My reference: 3/2021/0578
Direct Dial: (01200) 425111
www.ribblevalley.gov.uk
Email: planning@ribblevalley.gov.uk
Date: 20 July 2021

Location: 20-22 Talbot Street Chipping PR3 2QE

Proposal: Discharge of Condition 10 (Specifications of replacement windows) and Part Discharge of Condition 6 (Recording of First Floor) of Listed Building Consent 3/2020/0763.

PHOTOGRAPHIC RECORD OF FIRST FLOOR STRUCTURE: PHASE 1 REPORT

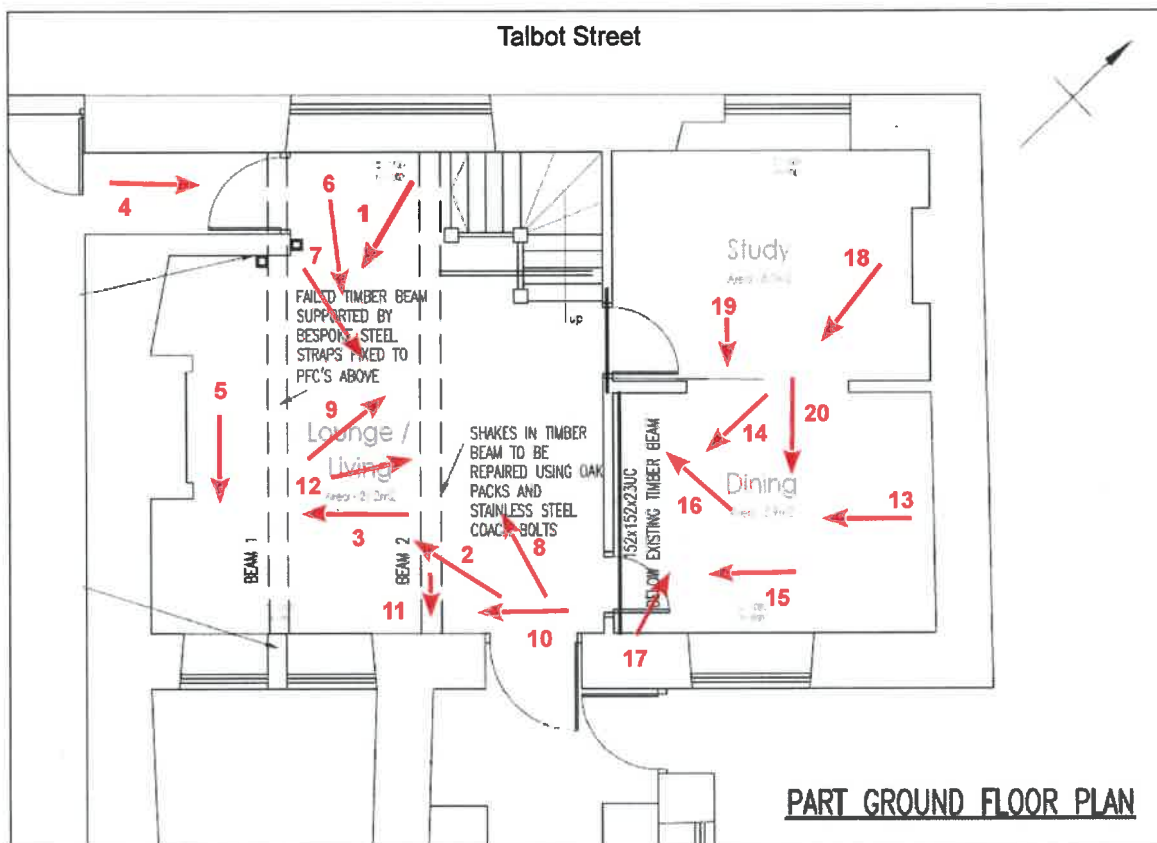
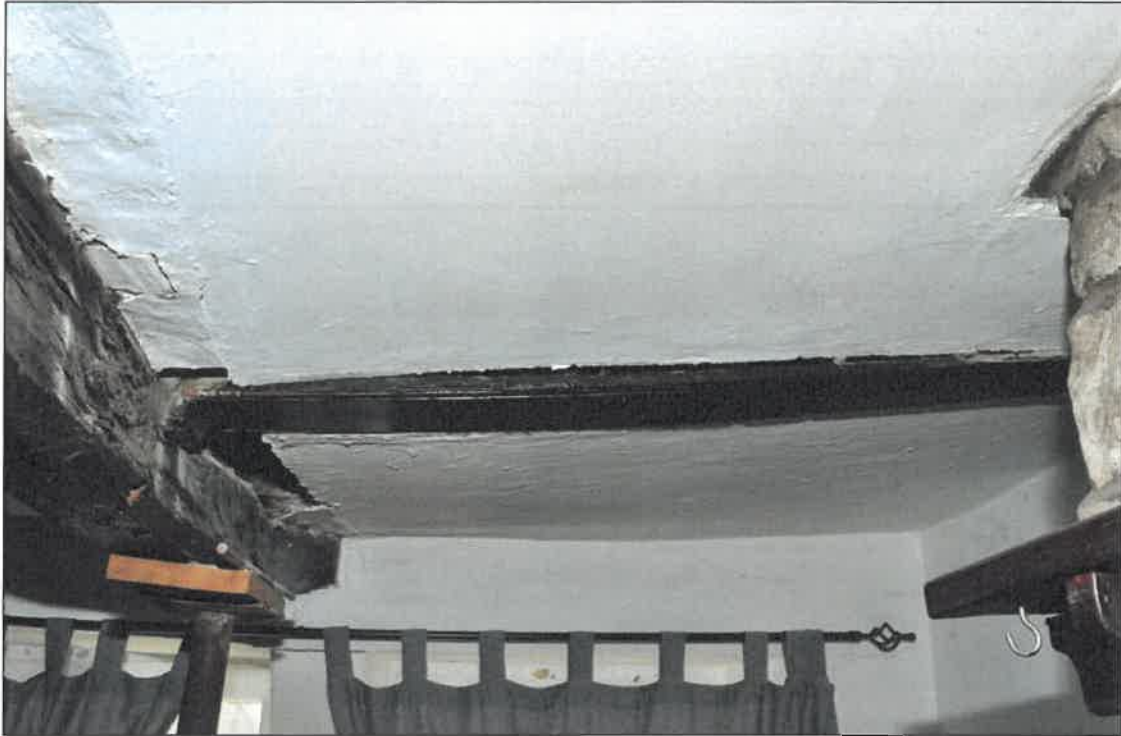
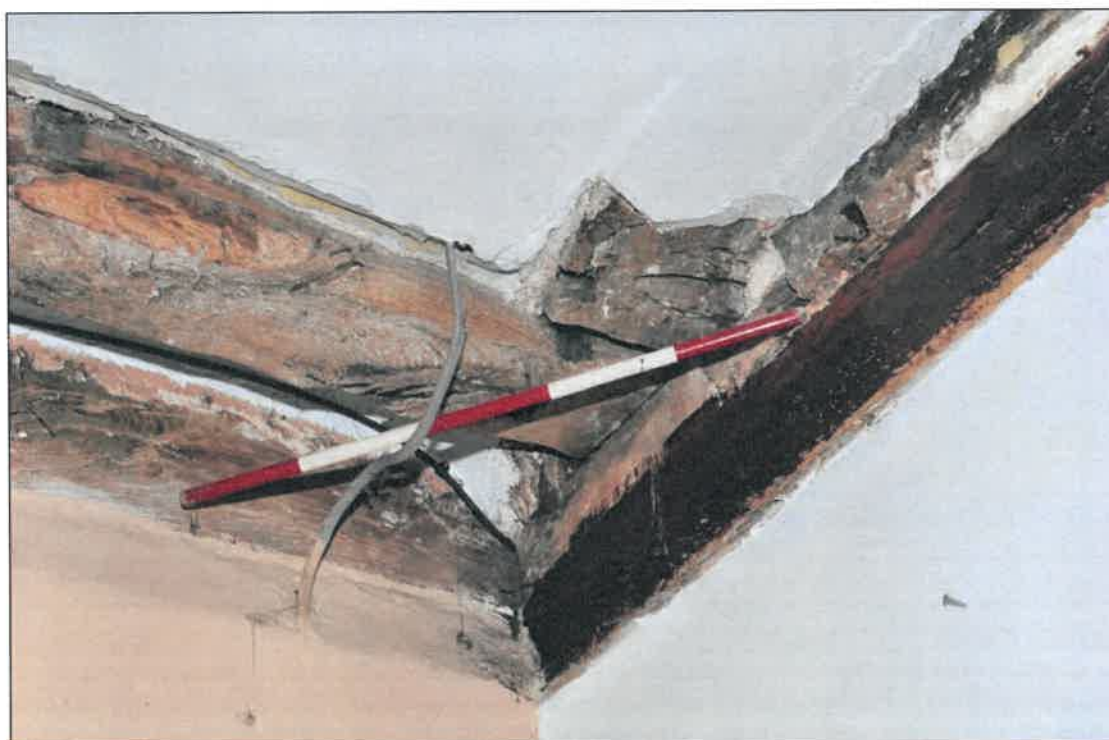
Part discharge of Condition 6 - Phase 1 Report only of the photographic record of first floor structure. Lancashire County Council Archaeology recommend part discharge of the condition.

- 1 Lancashire County Council Archaeology note that a full timetable for works has not been supplied. It recommends that the condition is not fully discharged until further recording has been undertaken and a revised report received.
- 2 The precise specifications (scaled elevation and sectional drawings) of replacement windows requested by Condition 10 have not been submitted.
